From: Zac Denton
Sent: 02 November 2017 10:01
To: [REDACTED]
Subject: R/1/17/T

I have received Arboricultural comments regarding your application for works at various locations across the Poplars and Parklands Estates, Rustington.

BROOKEN BEE

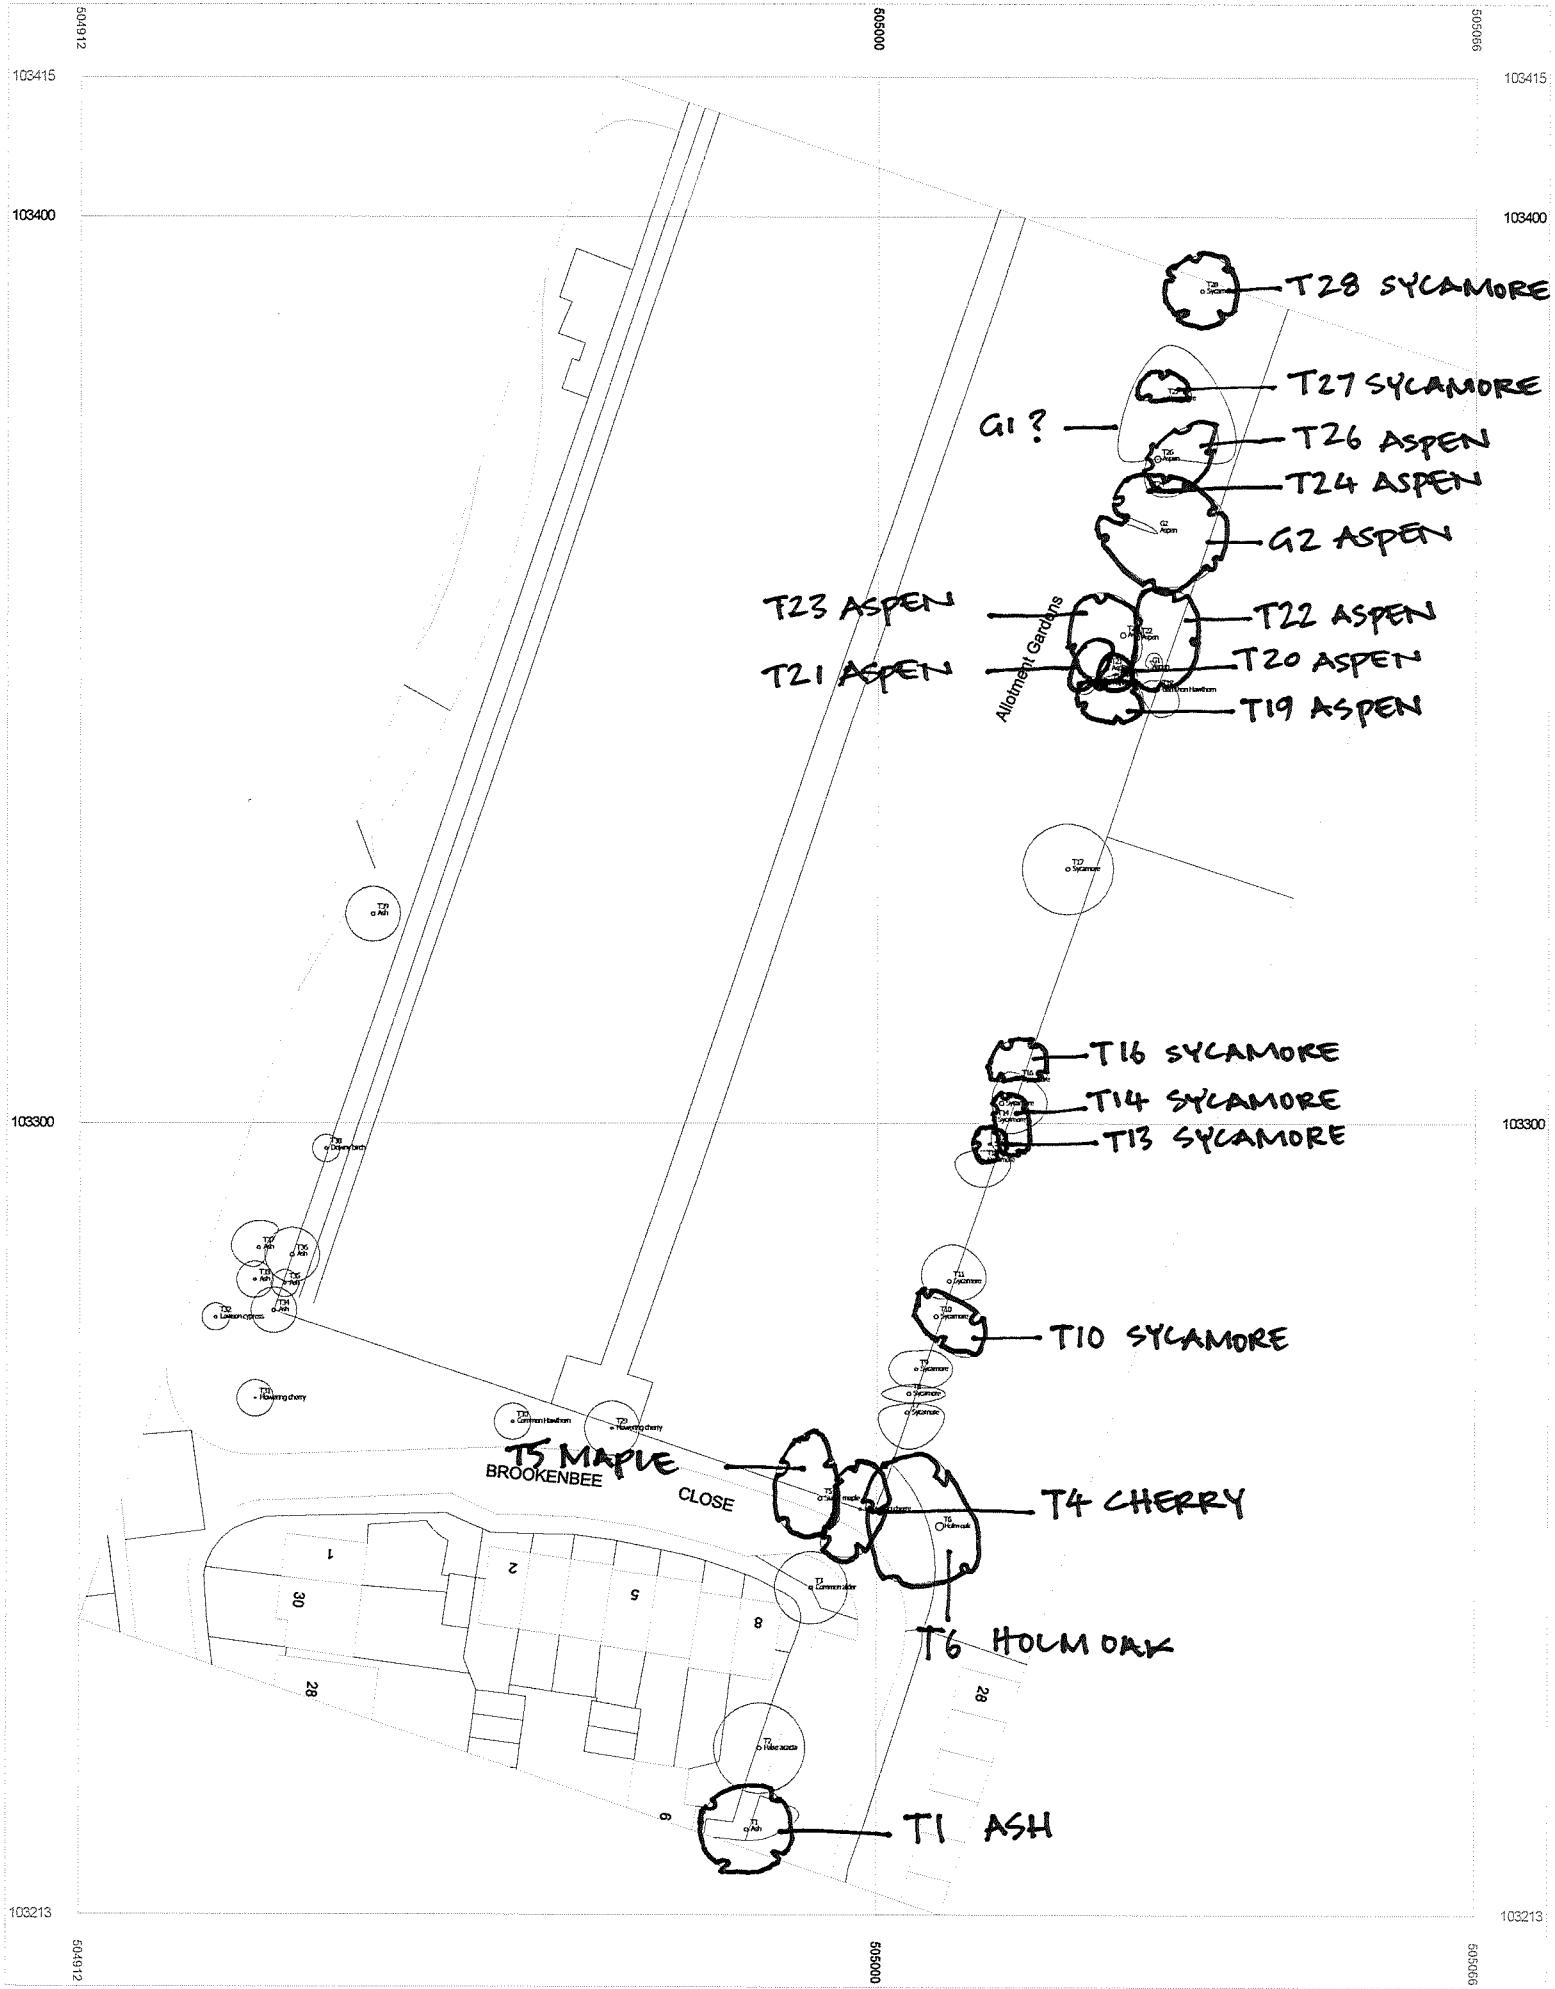
Please confirm that works to T16, T22, T23, T24, T26, T39 and T1 will no longer form part of the application, and will therefore require resubmission.

PARKLAND HUTCHINSON SUMMERLY FOXES, - NORTH

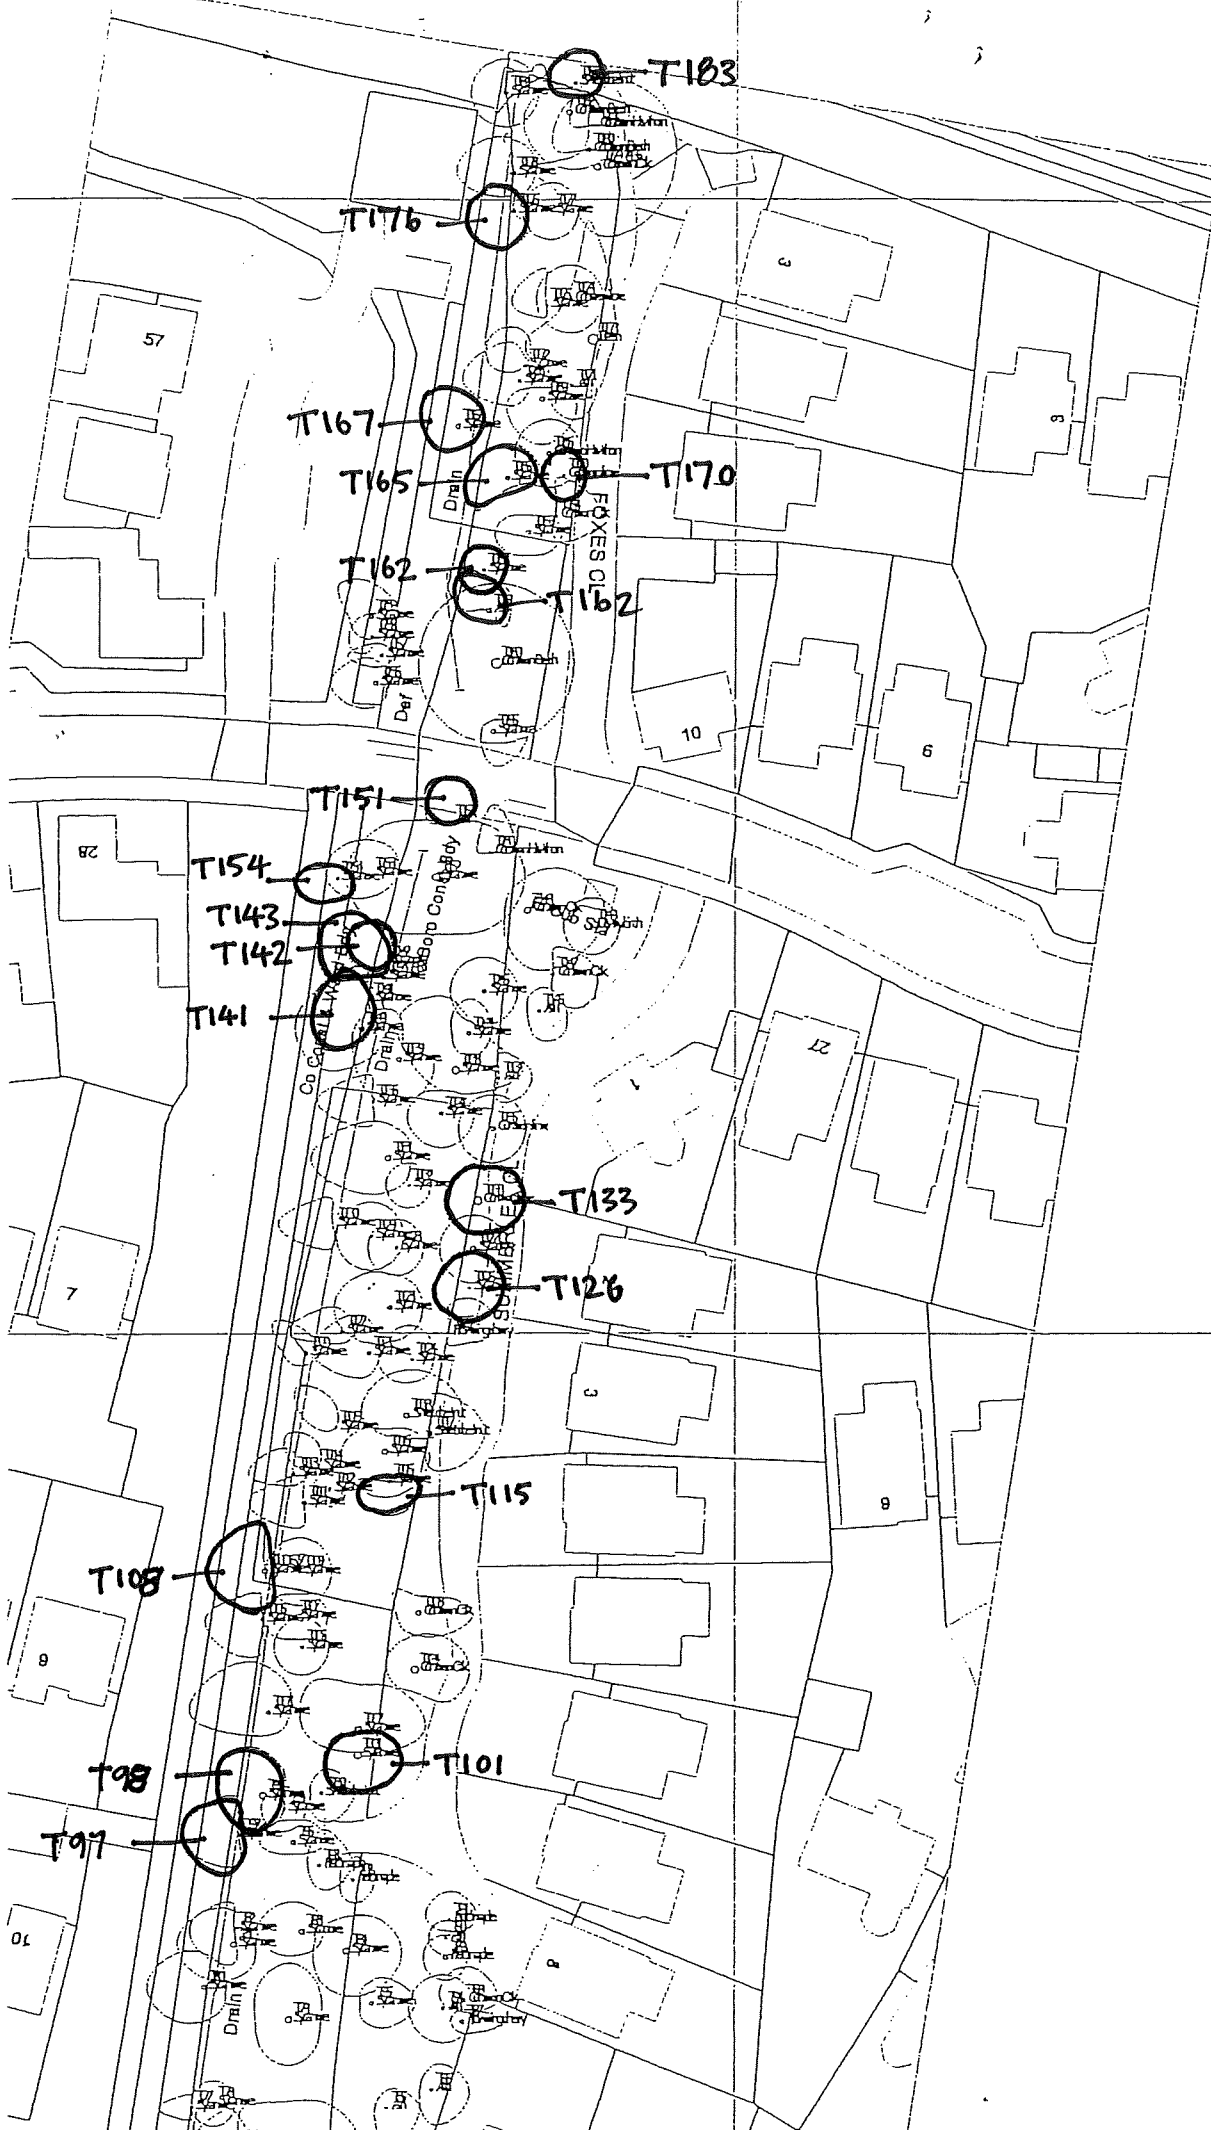
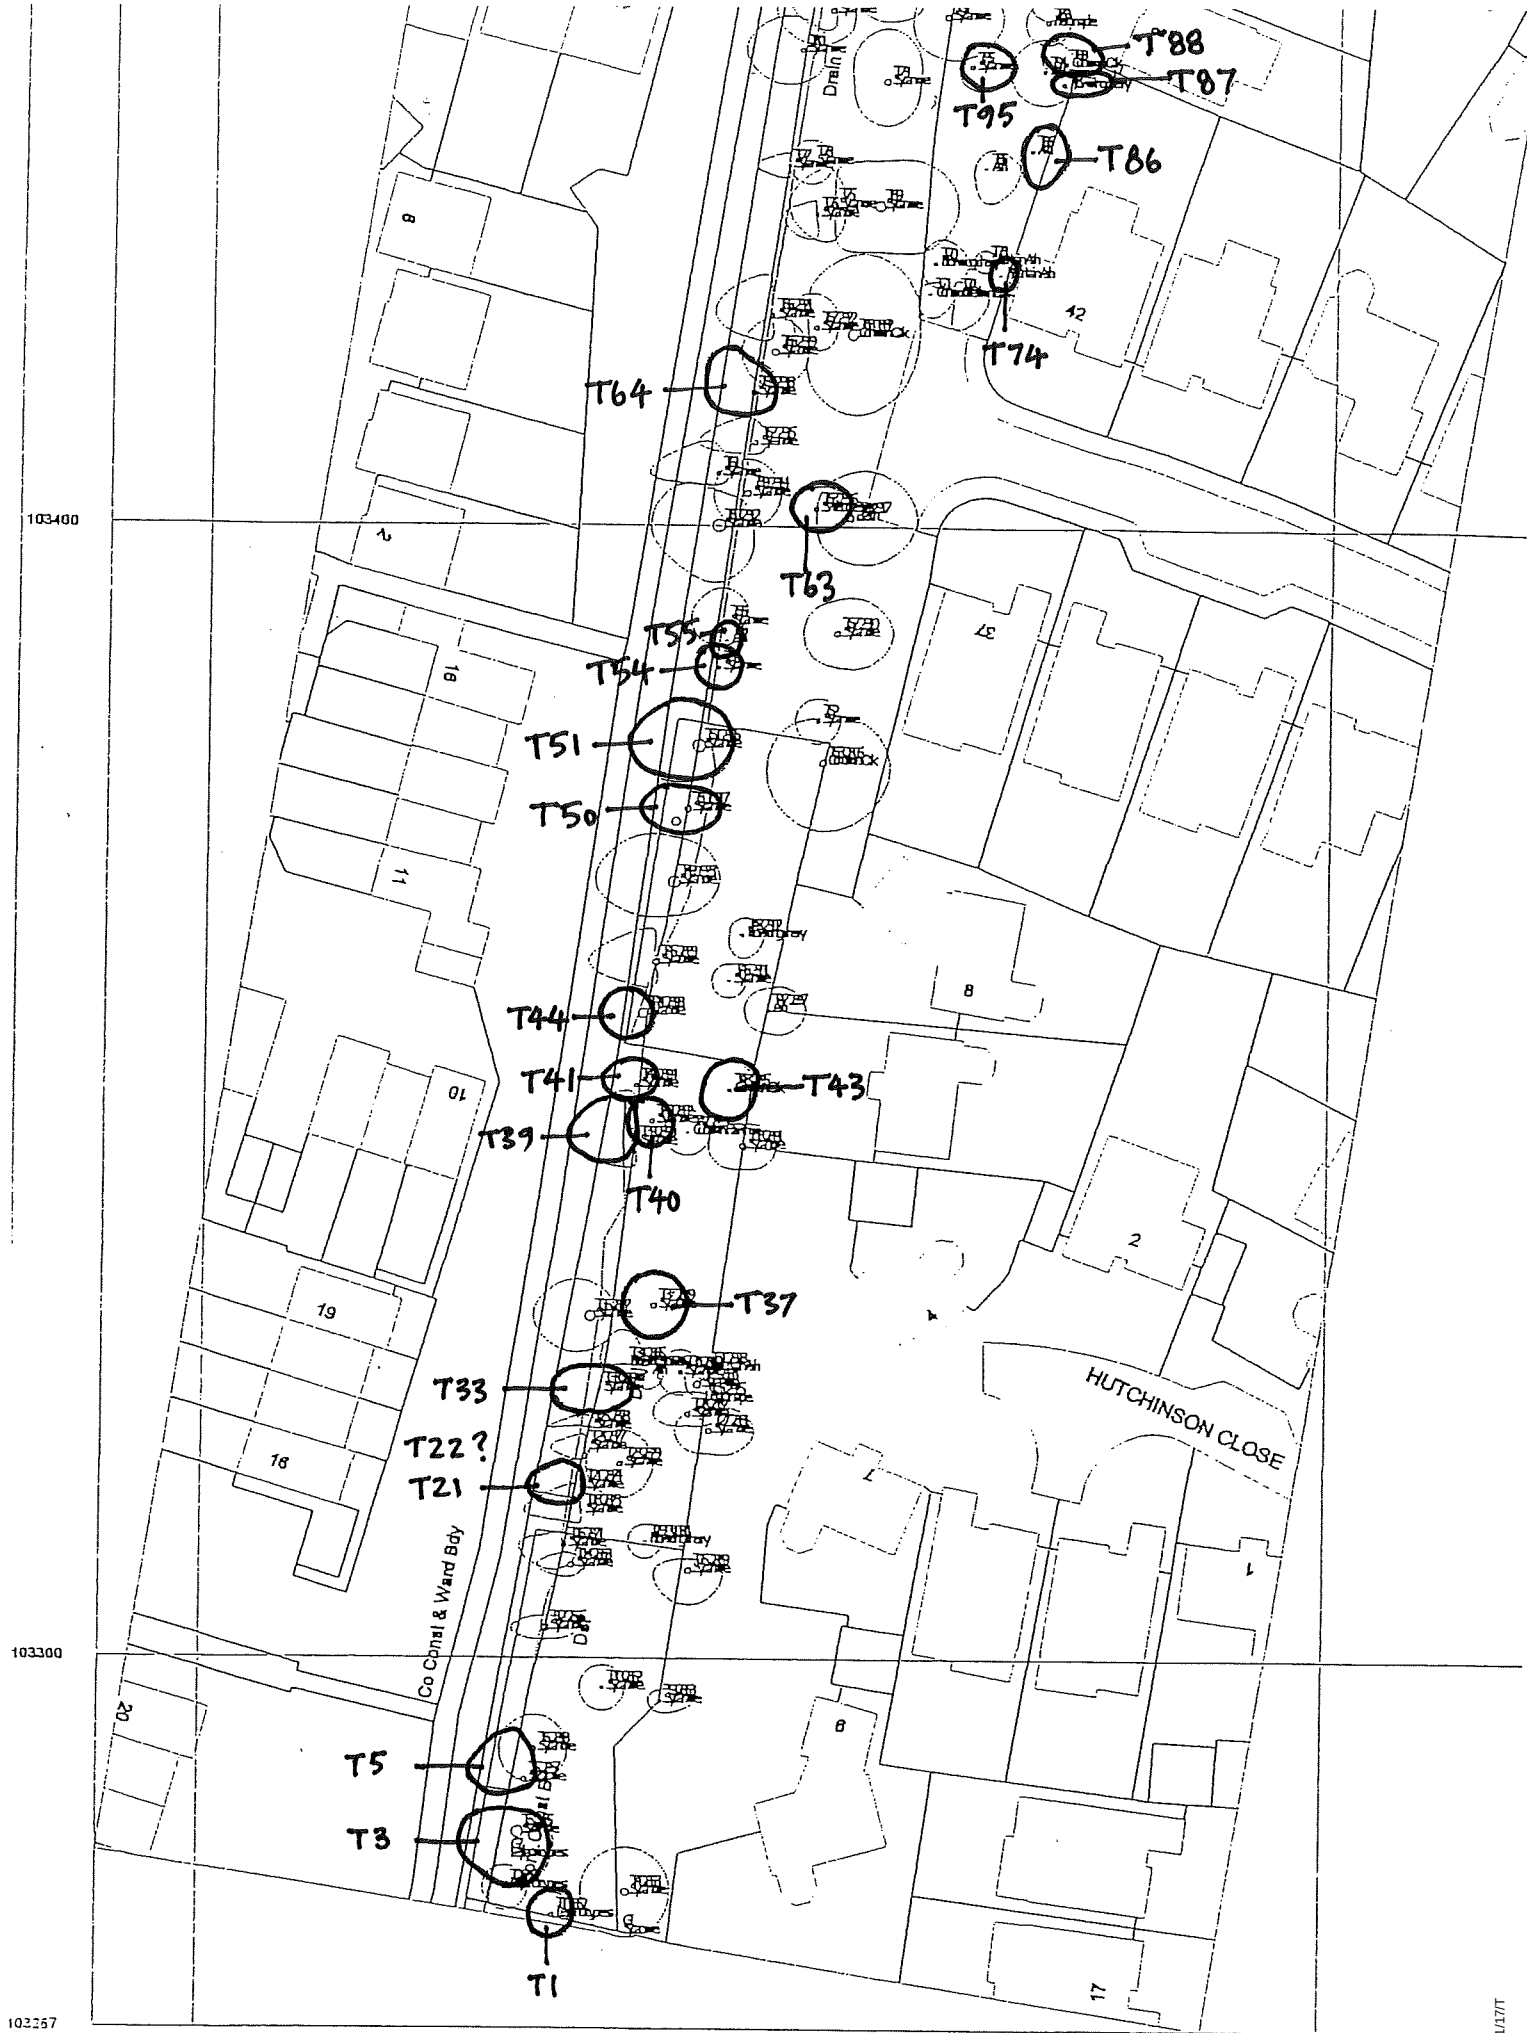
Please confirm that works to T5, T44, T141 and T160 will no longer form part of the application, and will therefore require resubmission.

PARKLANDS / COWDRAY DRIVE

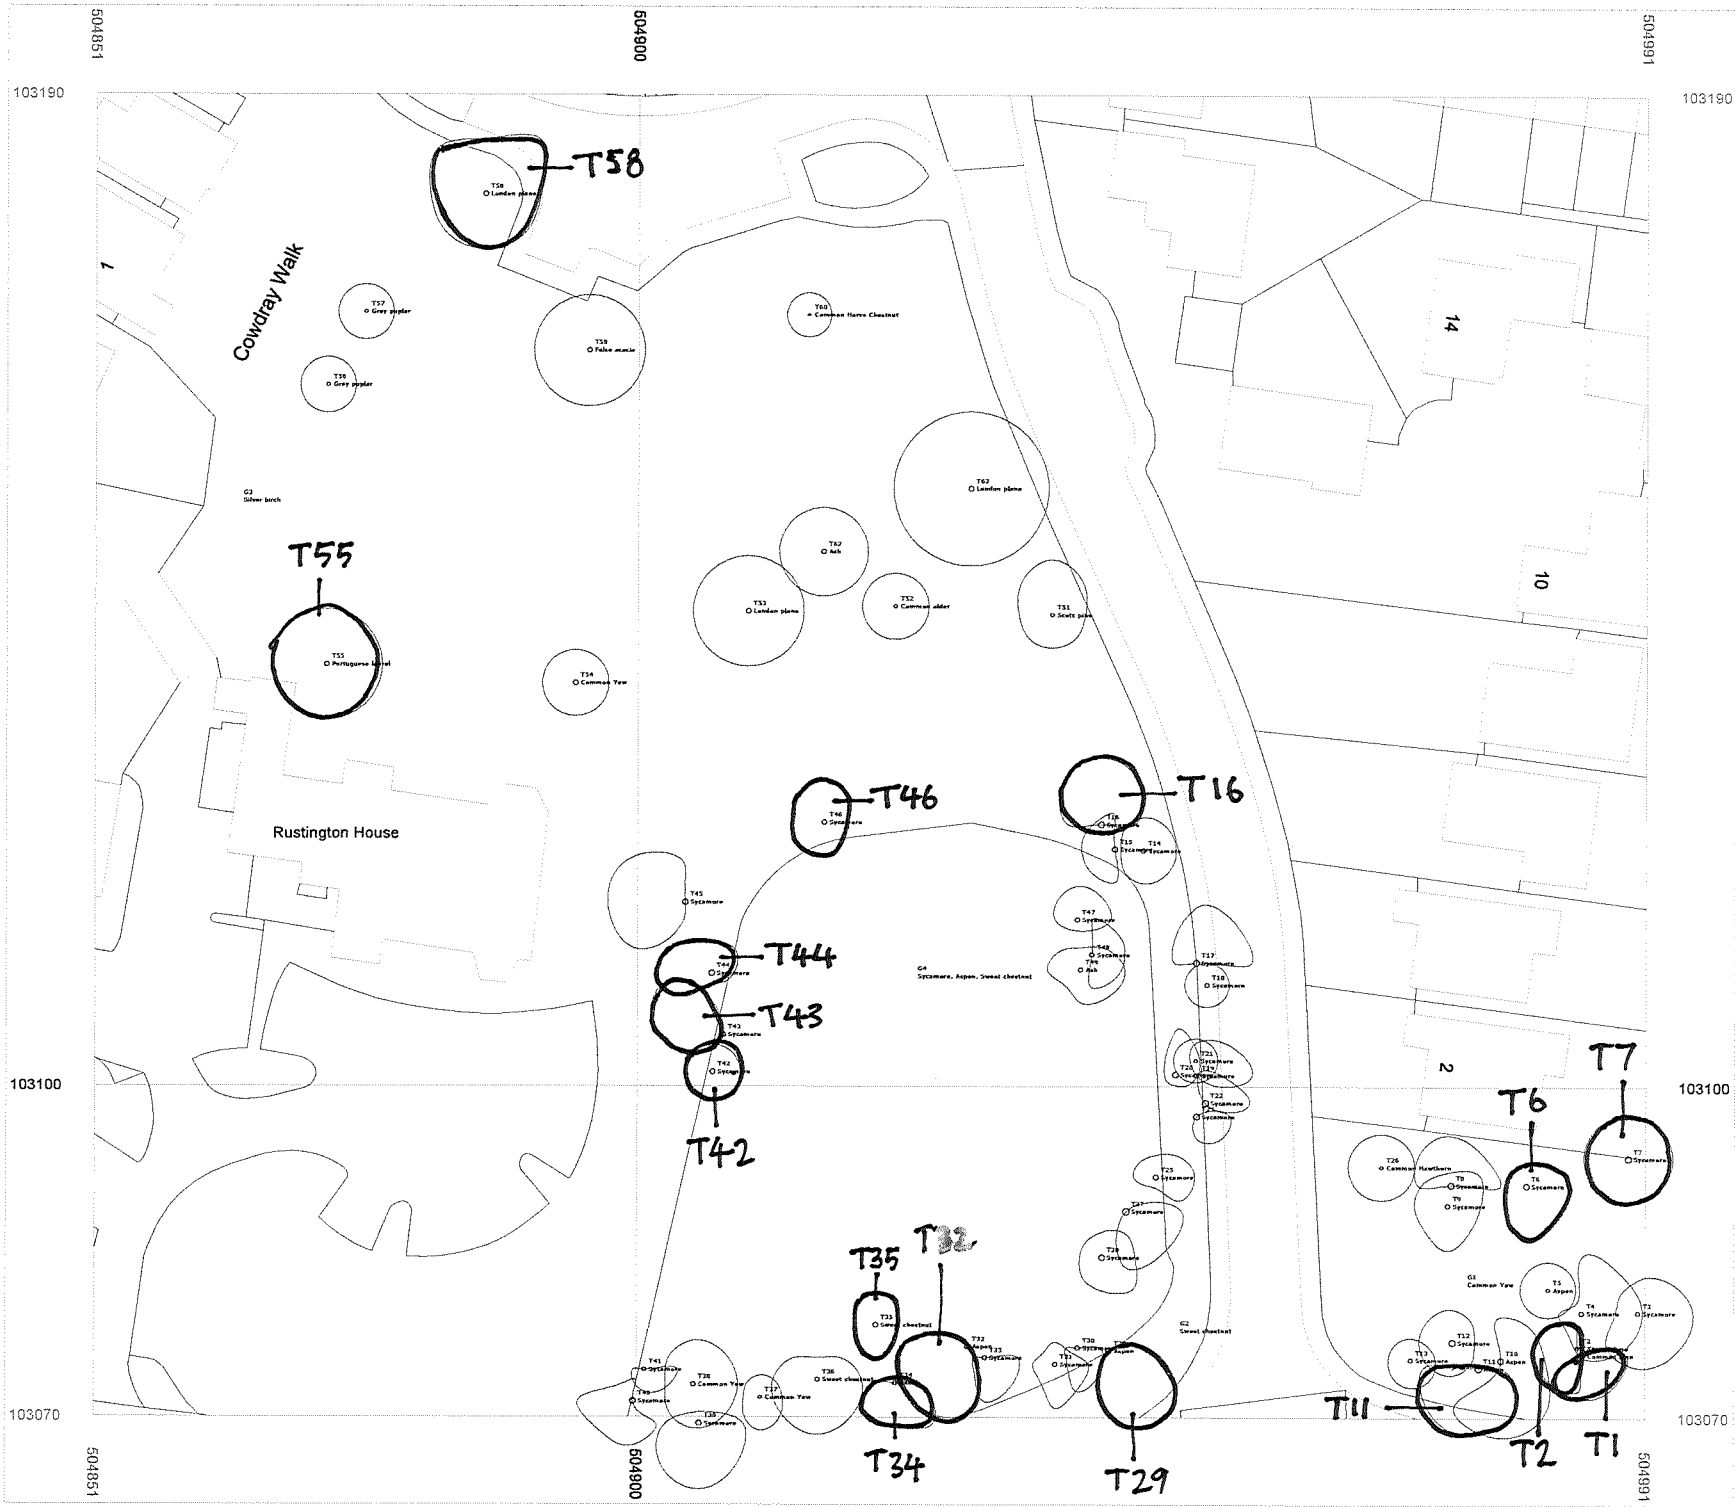
Please confirm that works to T6, T7, T11, T16, T34, T55 and T58 will no longer form part of the application, and will therefore require resubmission.
